**From:** Andrew Currin  
**Sent:** Tuesday, August 18, 2020 9:07 AM  
**To:** 'Misty Lyons'; maggiemay020283@gmail.com  
**Subject:** RE: Lot 4 Ashe Ave  
**Attachments:** Requirements for Submittals of Soil Reports and Pretreatment Systems.pdf

Owner: ASHE TRAIL  
 Address: LOT 4  
 Location: ASHE AVENUE

Canady Site
3603 Ashe Ave
Dunn NC

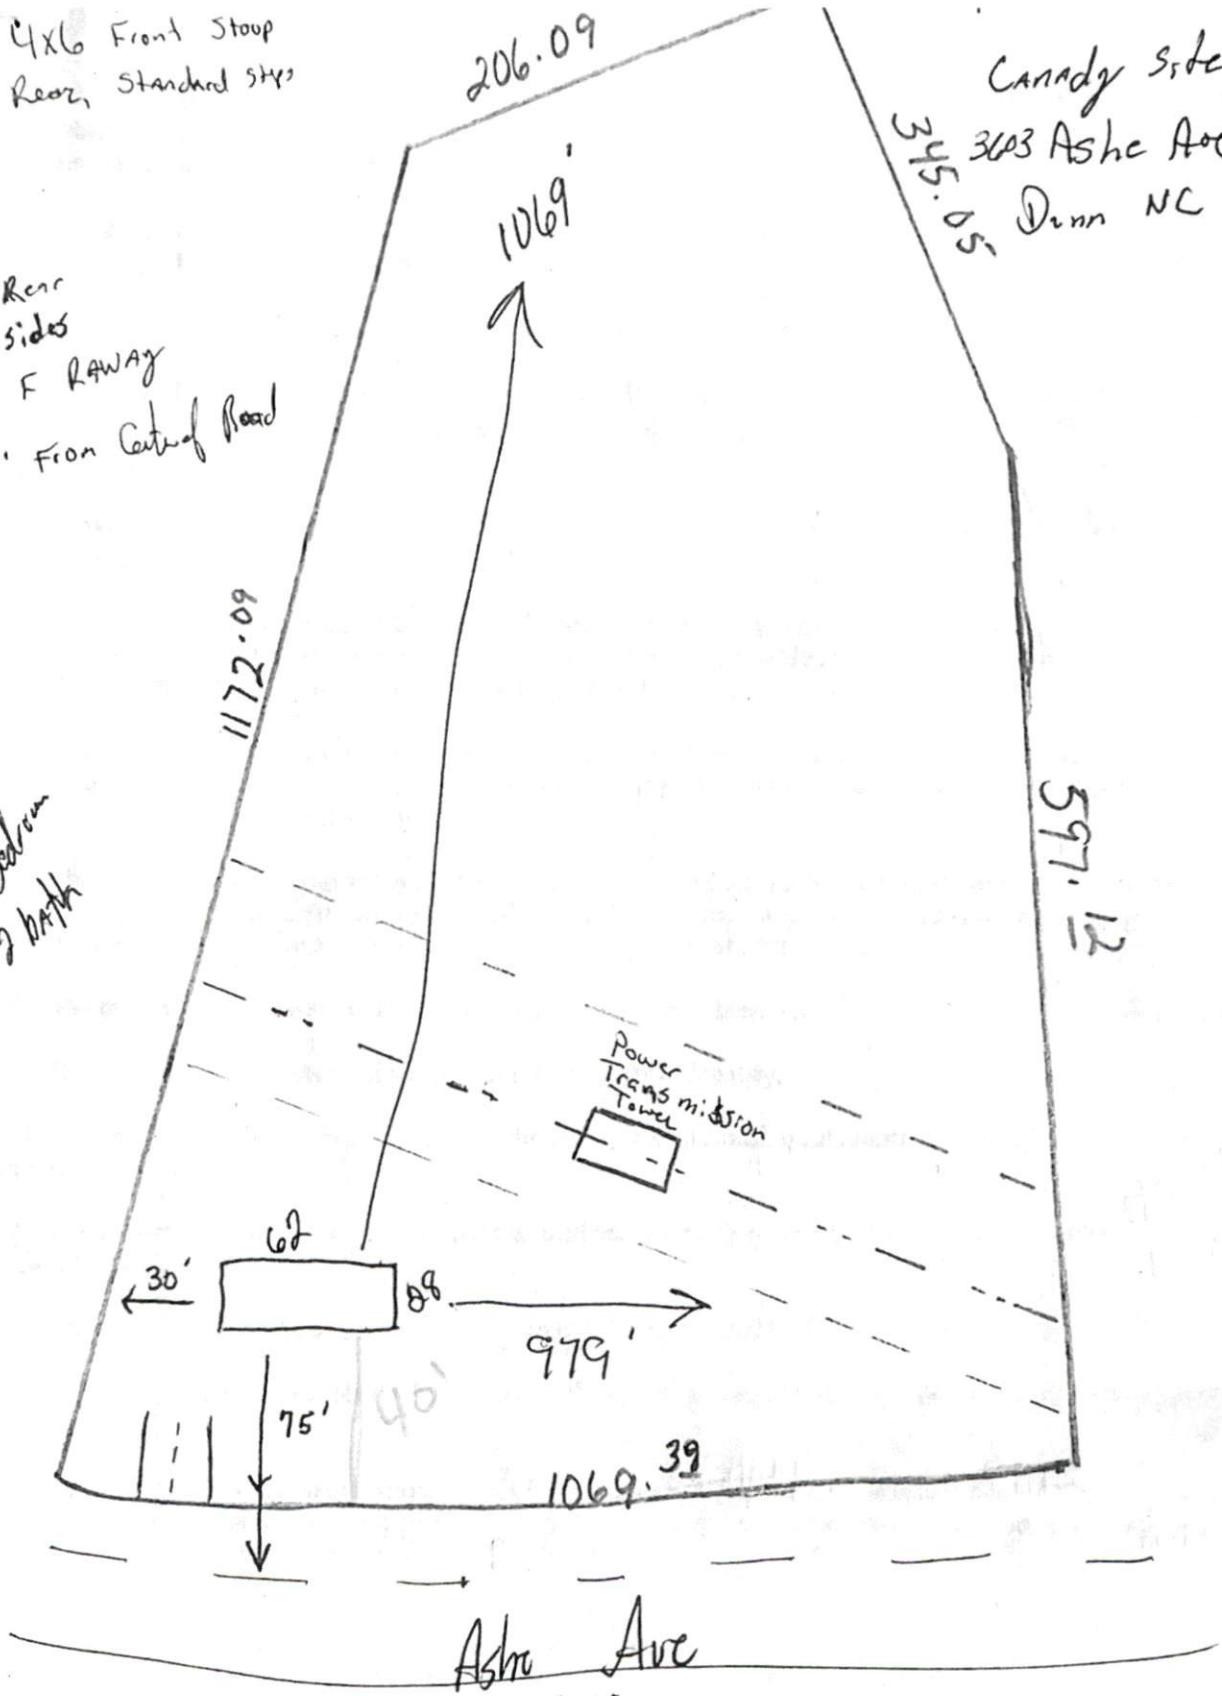
- 1) The Soil Report sent over is for an Engineered Option Permit (EOP) originally documented by Pittman Soil Consulting. Due to the advanced system (TS-II Pretreatment) repair, a detailed proposal must be provided by a Licensed Soil Scientist (LSS). Additionally, due to the tight and shallow nature, an onsite layout of initial and repair is required. The lot cannot be approved without a detailed proposal and onsite layout. Attached you will find guidance of the requirements for submittal for the Licensed Soil Scientist (LSS).
- 2) Surveyed Property Irons shall be exposed and clearly visible. Surveyed property lines shall be clearly marked in vicinity of home site (left side, front).
- 3) Revised SWMH location – Per the proposed soil report, the SWMH will need to be relocated and site plan revised to be out of whatever septic layout is proposed by your Licensed Soil Scientist (LSS).

Note: The rough layout proposed by the Soil Scientist is for a gravity system. Due to landscape position, gravity requirements, and size of system I would factor in the initial system being a pump system but I will let the Soil Scientist propose.
